**Re: Lindo Mexico Cantina Addn.
7209 Central Ave NE
Traffic Circulation Layout**
Engineer's/Architect's Stamp 1-26-21 (K19D144)

Based upon the information provided in your submittal received 1-27-21, the above referenced plan cannot be approved for Building Permit until the following comments are addressed:

1
TCL

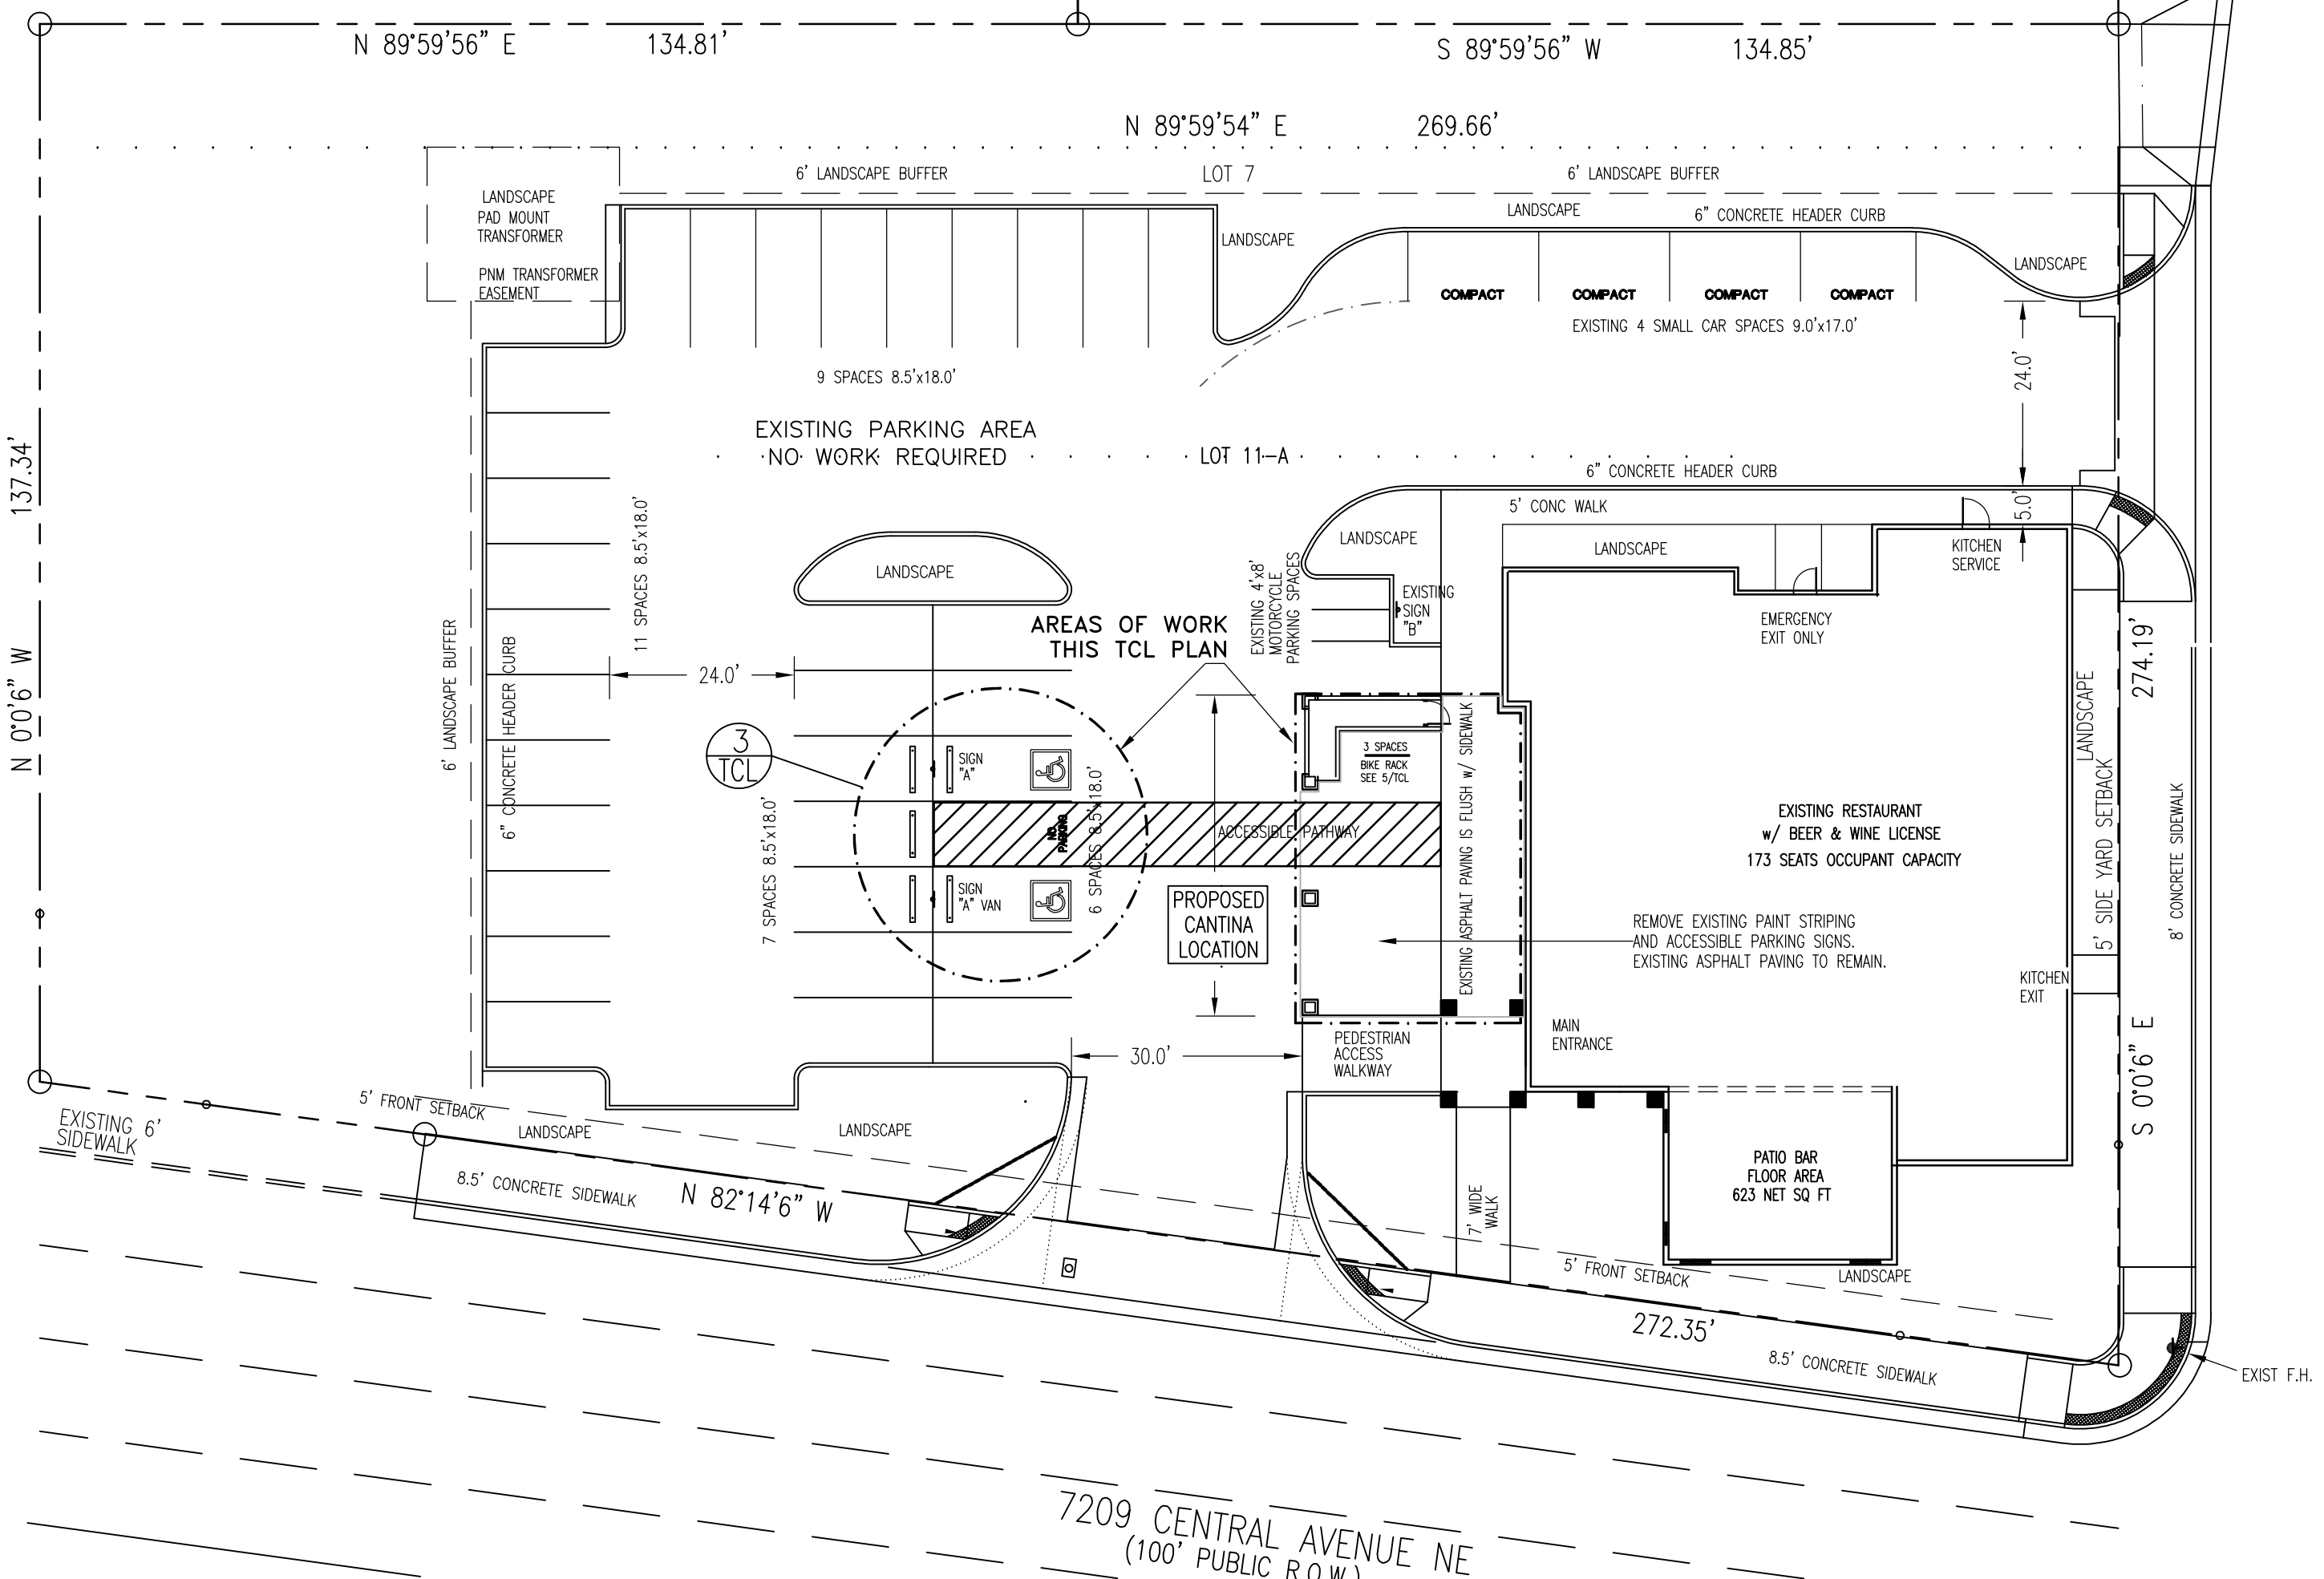
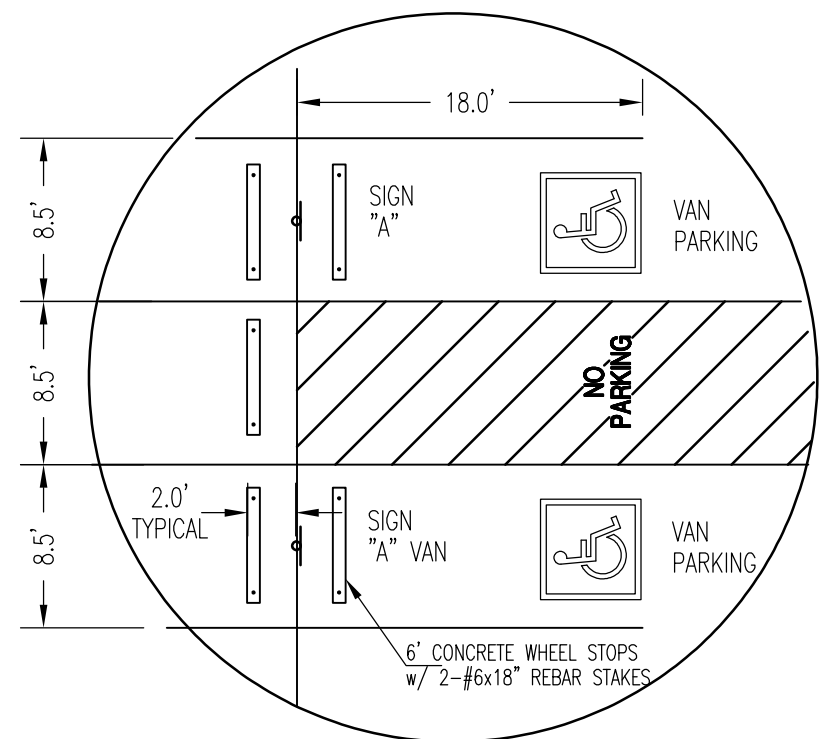
- Clearance between stairs and ADA stall show two dimensions 4.3' and 2.2'. Please clarify. Minimum of 4' required for pedestrian access and bicycle parking.
- Stairs and Deck post appear to affect clearsite visibility for the ADA stalls. Please provide clearsite exhibit. And add note: "Walls and Post will not interfere with clear sight requirements. Therefore, signs, walls, trees, post larger than 8 inches in diameter, and shrubbery between 3 and 8 feet tall will not be acceptable in the clear sight triangle."
- Please provide header curb detail. (Motorcycle Parking)
- Please provide bike rack detail.
